Our ref: DOC22/878399

Your Ref: SSD-32927319

Subject: Request for Advice: Response to Submissions for Powerhouse Ultimo Renewal (SSD-32927319)

**ZONE 3:**  
(Also to apply to area along northern site boundary below Pier Street overpass)

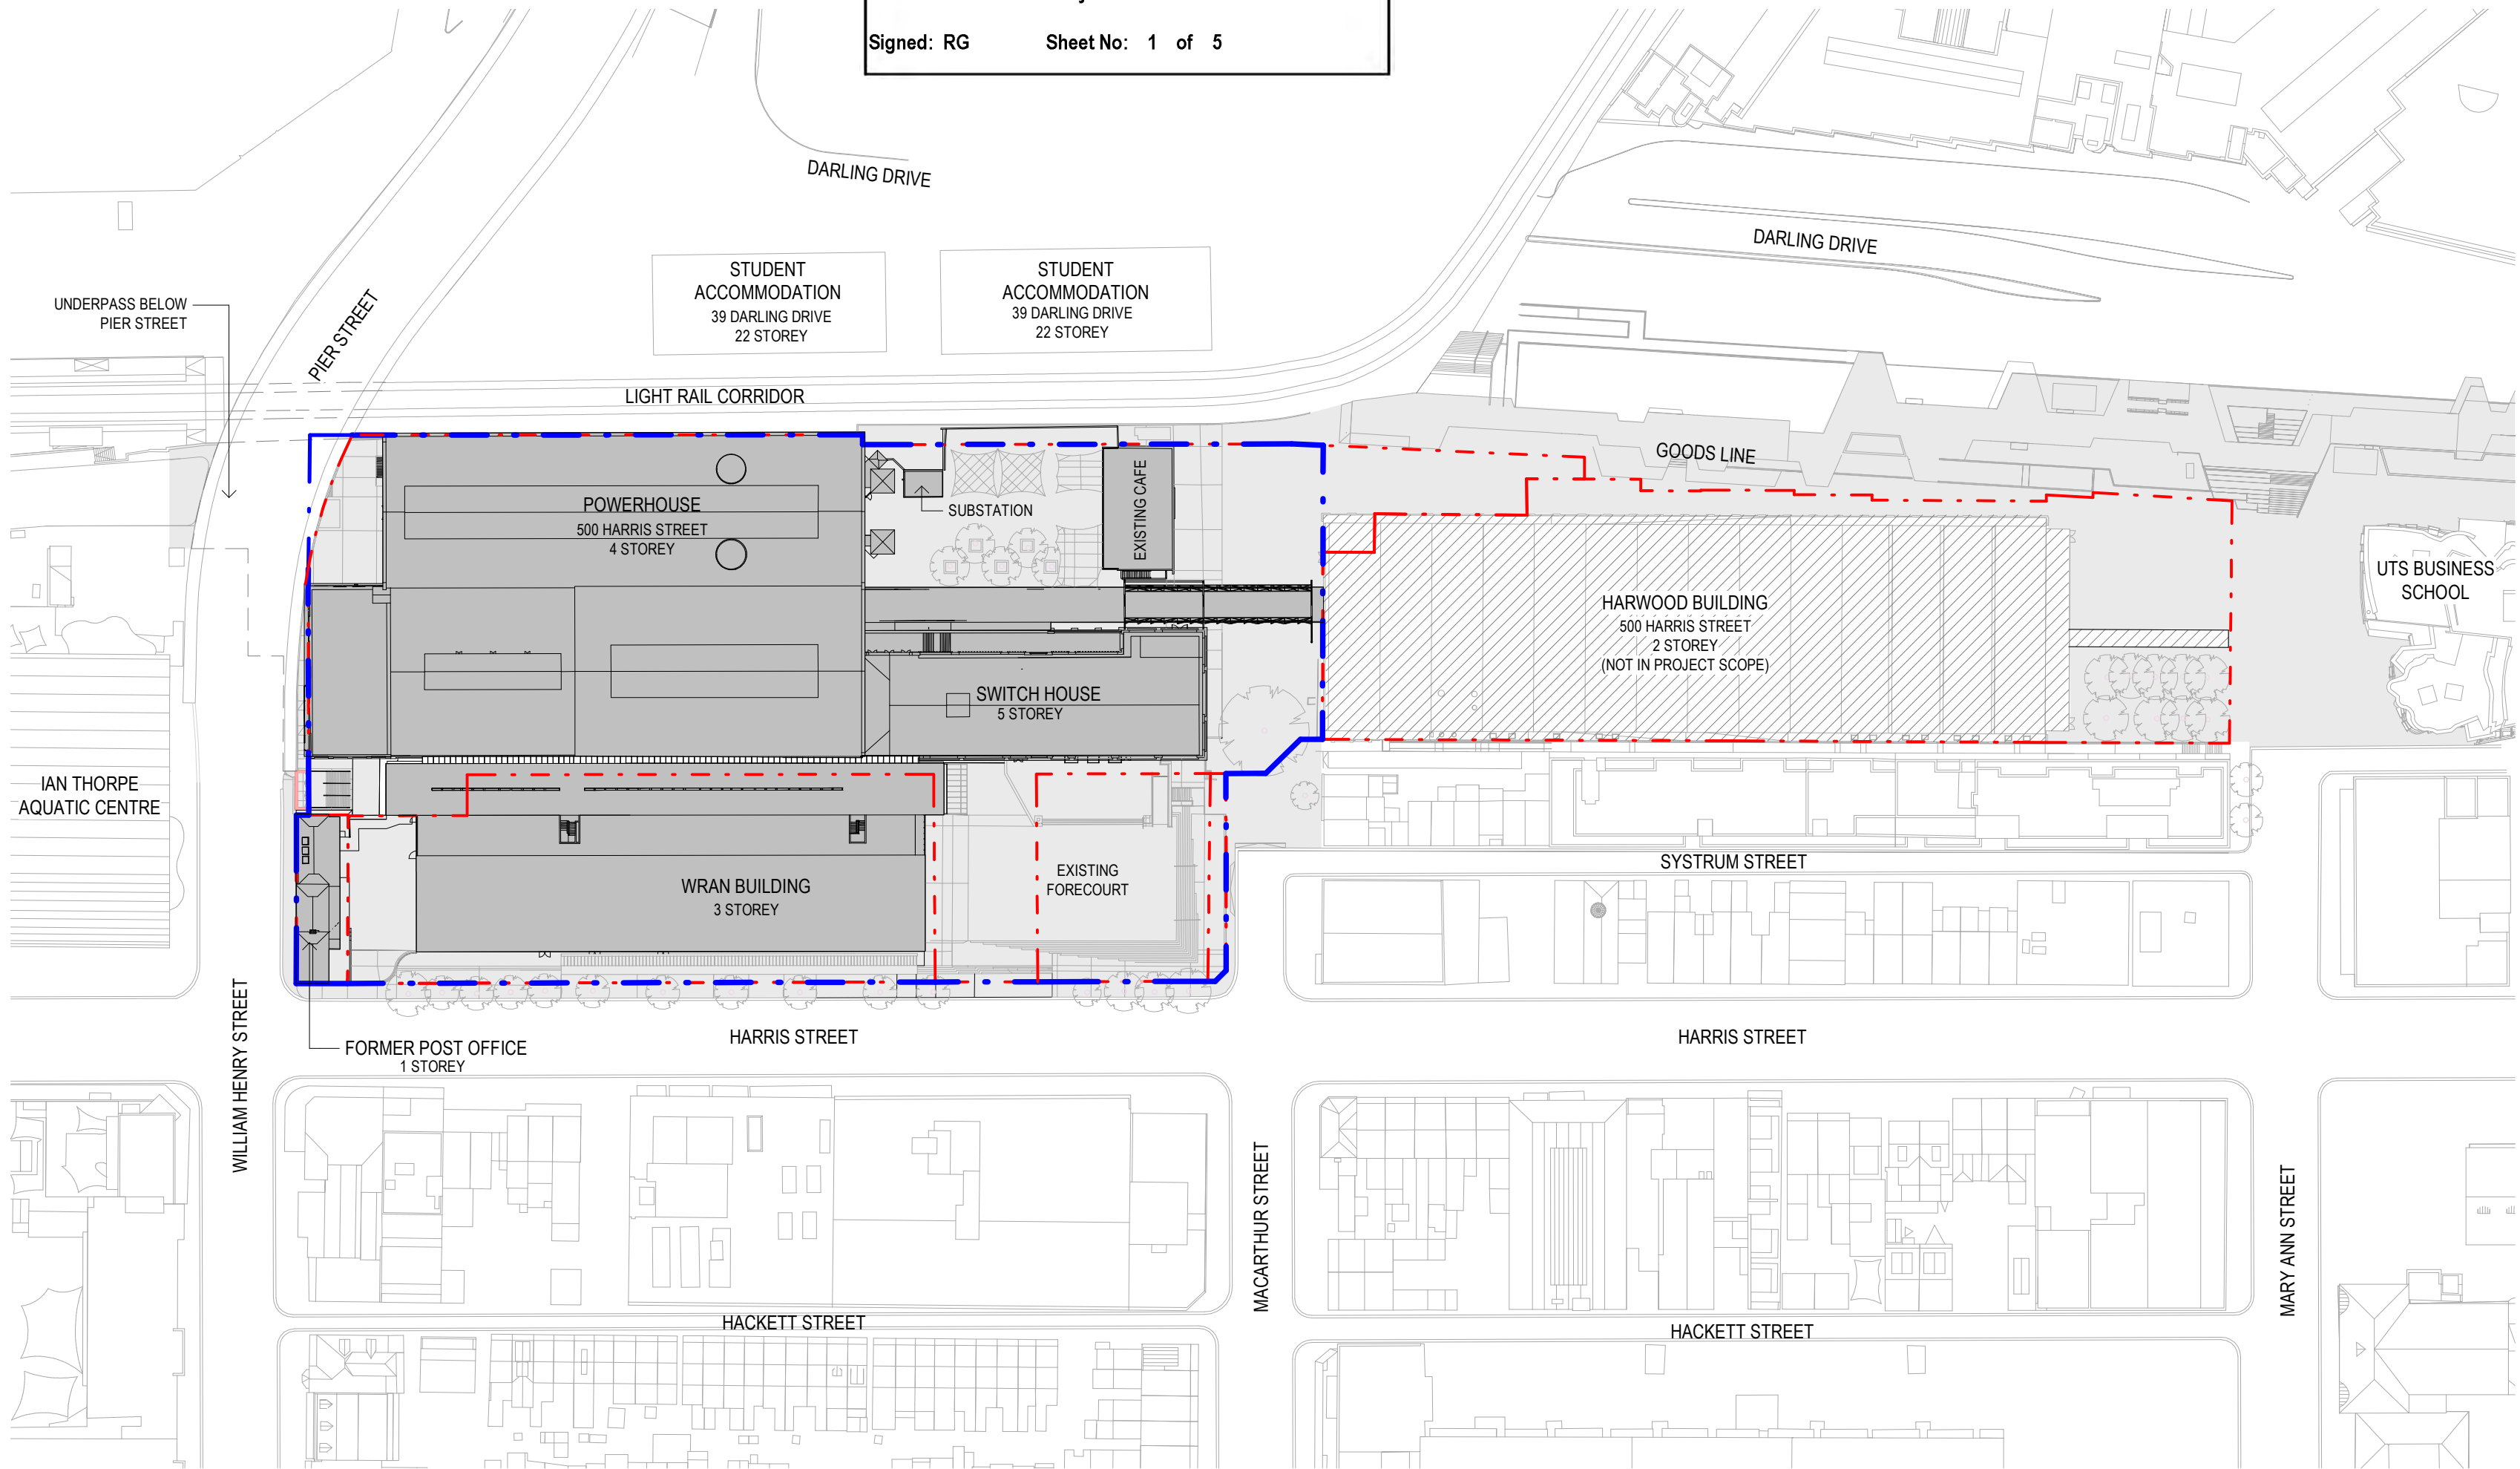
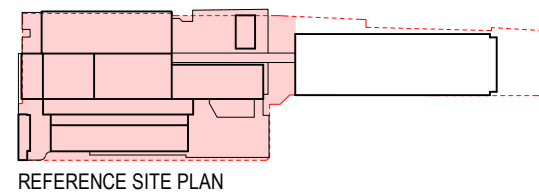
The development of Zone 3 (the northeast corner) is predicted to cause unacceptable flood impacts. Consideration should be given to retaining this area at existing ground levels or reducing the planned extent of the building to avoid impacts. It is not considered reasonable to proceed based on the predicted impacts. The feasibility of any proposed mitigation measure must be shown, noting that stormwater upgrades in this environment even if feasible, would likely be costly.
